Recommendation Report for Works to Tree(s) on trees subject to a Tree Preservation Order (TPO)

REF NO: FP/248/18/T

LOCATION: 29 Westmorland Drive
Felpham
PO22 8NA

PROPOSAL: Crown clean & 1-2m reduction on circumference to 1 No. Field Maple tree.

REF 1

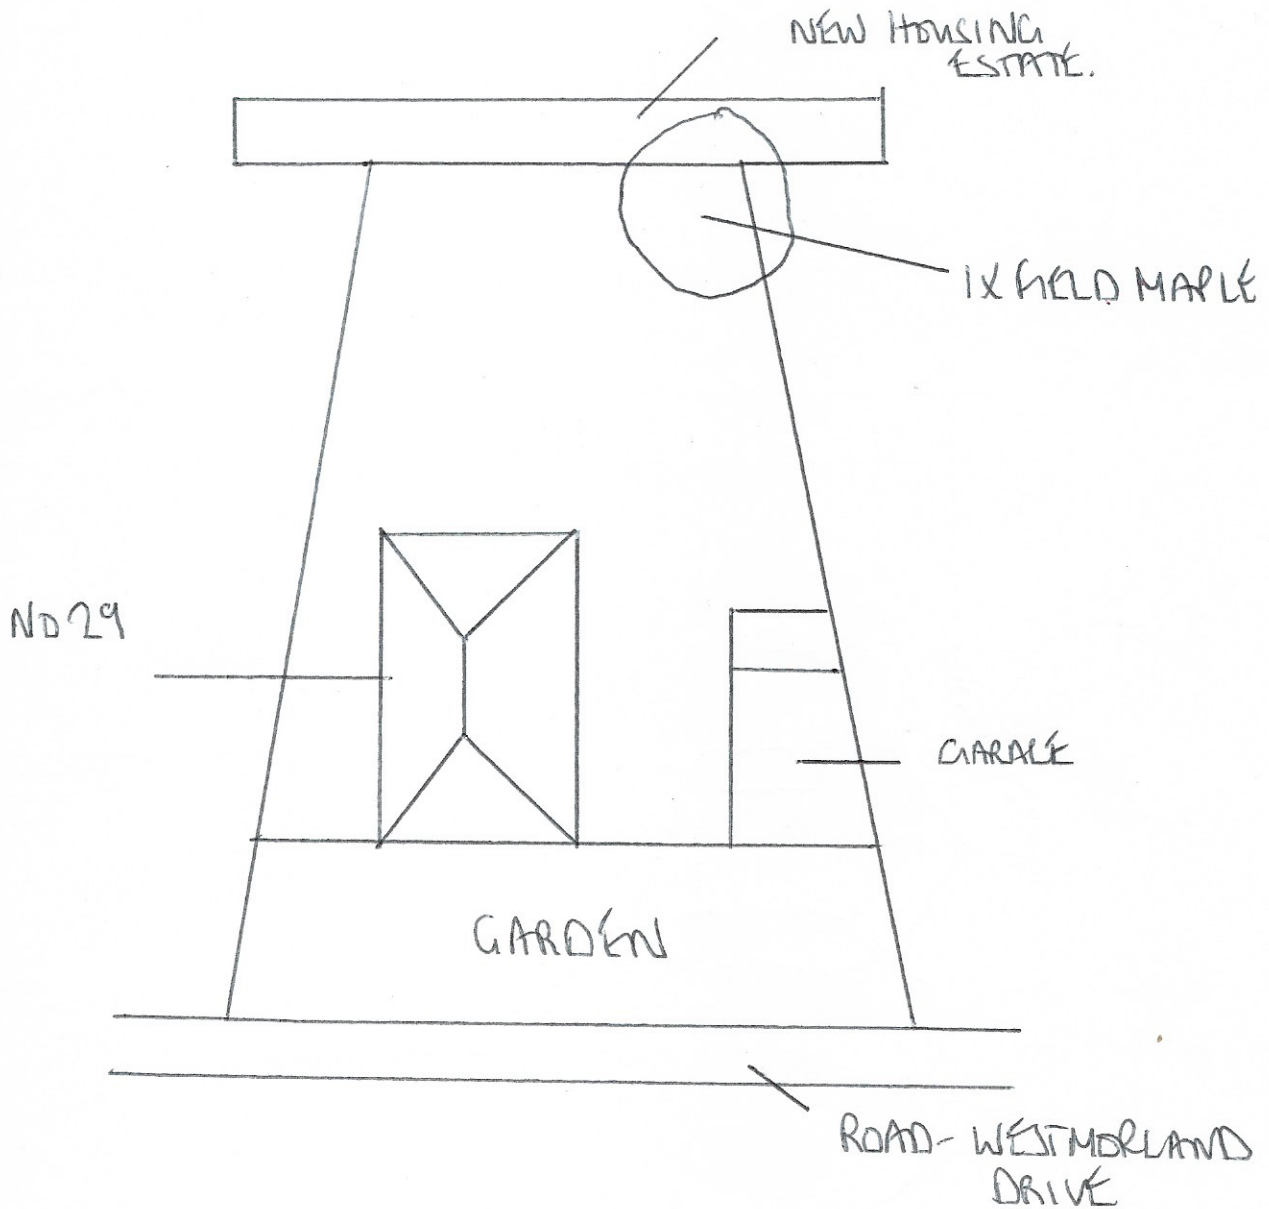
- This tree appears to be outwardly healthy and stable with a heavily modified crown. Its growth rate has likely been checked following the recent housing development work locally.
- It forms part of an established boundary tree-line, now placed under considerable pressure arising from the aforementioned development. Crown volume for this tree is low relative to its overall mass- so 1metre should be considered the maximum crown reduction on all aspects (including height) with the exception of property overhang to the west which could tolerate a 2metre reduction.
- It grows at the rear of the property and can be seen from neighbouring dwellings but has only limited visibility from publicly accessible land.

- This tree requires careful management that respects its age and past development pressure.
- If the work is undertaken to a good standard and at the right time; then it is unlikely to have an adverse effect on the tree's long-term vitality.
- There should be no significant loss of public amenity on completion of the proposed works.

- Where whole branches are to be removed and final cuts made close to the trunk or branch union they are to be made as shown in Figure 2 of BS3998:2010
- Where branches are to be shortened back the final cuts are to be made at the correct angle shown in BS3998:2010 and adjacent to a live bud or lateral.
- The long-term vitality of this tree is best respected when significant pruning work such as proposed, is undertaken during either the summer (June to August) or mid-winter (mid-December to January) periods. The work proposed must only be undertaken during these periods.
